ABP— 314485-22

Planning Authority: Fingal County Council

An Bord Pleanála appeal case number: PL06F.314485

Planning Authority register reference number: F20A/0668

Figure 13-3: 65 dB L_{den} Noise Contours, 2018 Baseline (blue), 2019 Baseline (red), 2022 Baseline (cyan), 2025 Baseline (yellow) and 2025 Consented (black)

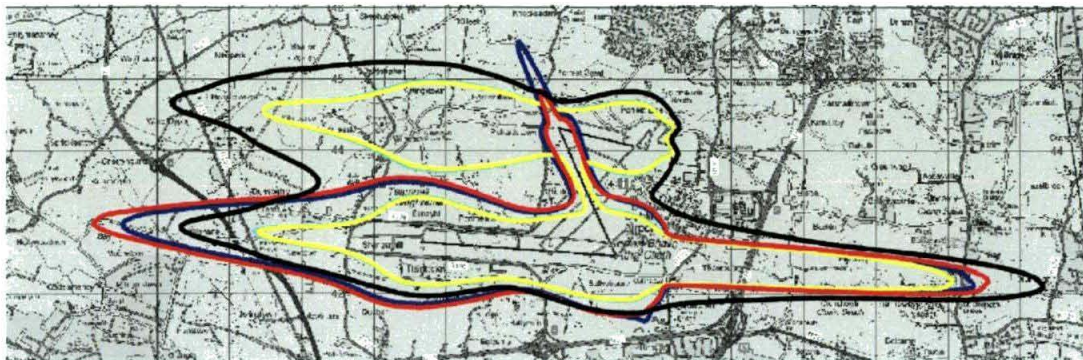
I request An Bord Pleanála to fully consider the noise contours used in the EIAR to determine predicted noise impact. Are these the option 7b noise contours permitted in condition 3 of the permission for the north runway granted in 2007? If so then the EIAR is flawed as it is not assessing the actual locations that will experience noise as a result of the changes. Do the noise contours which predicted noise impact is based on show the current flight paths in use which are substantially different from those permitted under condition 3? If so then the assessment of impact is inaccurate. In this case it would appear that the information contained in the EIAR does not identify the significant effects that may arise from the RA or the extent of population that will be impacted and does not adequately assess the likely significant effects as required by the Planning and Development Regulations, 2001 (as amended).

Figure 13-6: Extract from Local Area Plan – Noise Zones

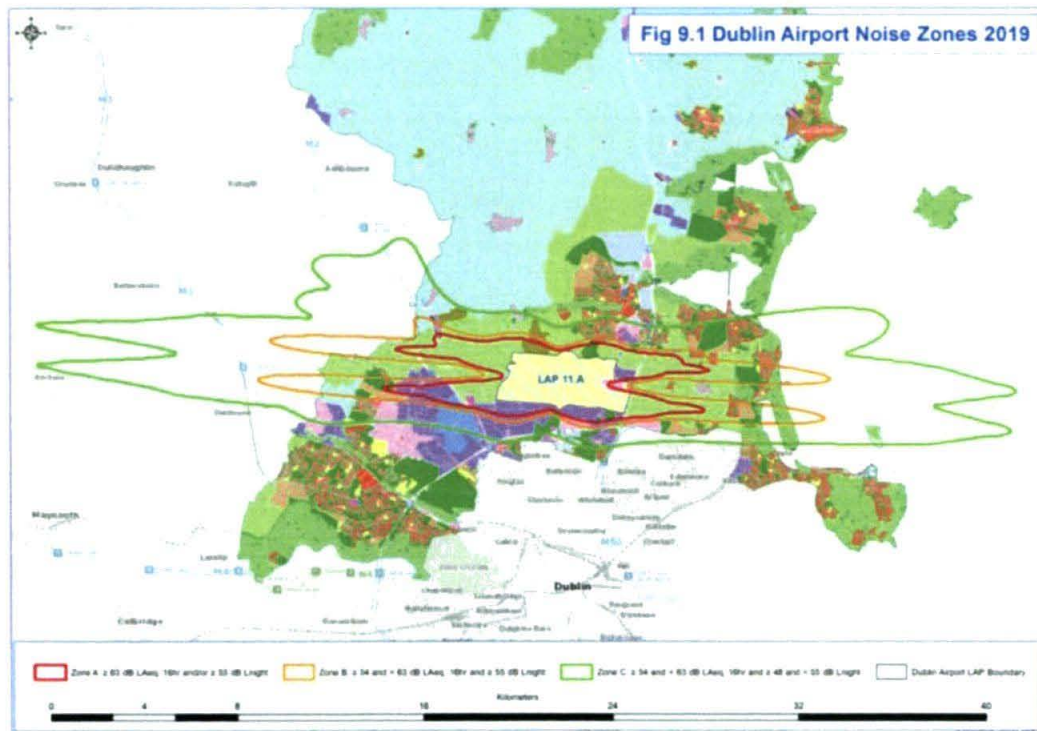
Figure 13-6 refers to 65dB Lden noise contours for 2018, 2025 Permitted and 2035 Permitted. However, the actual current use of the north runway is not reflected in these contours. I have measured aircraft noise at The Ward well in excess of 65dB outside of the contours shown on map 13-6 in the EIAR. I consider the EIAR is flawed in its portrayal of predicted noise contours and resulting impact of the RA.
